MARKSHEFFEL CROSSING- AIRPORT OVERLAY

JUNE 2026; REVISED AUGUST 2026

FILE #: SKP-26-001

COLORADO SPRINGS AIRPORT OVERLAY DISTRICT

COLORADO SPRINGS AIRPORT OVERLAY DISTRICT

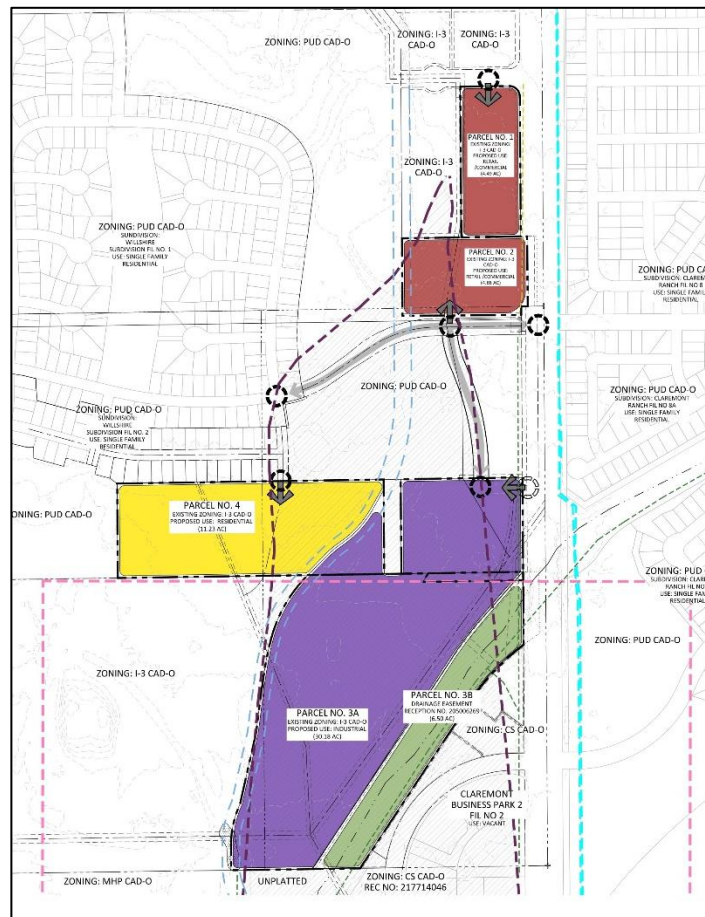
The Code states the BOCC shall make the finding now and included in the resolution. No actual mitigation has been provided. This is not a noise study. What are the actual measurements for dba on the property in the area? what is the mitigation recommended by the acoustical engineer for residential homes?
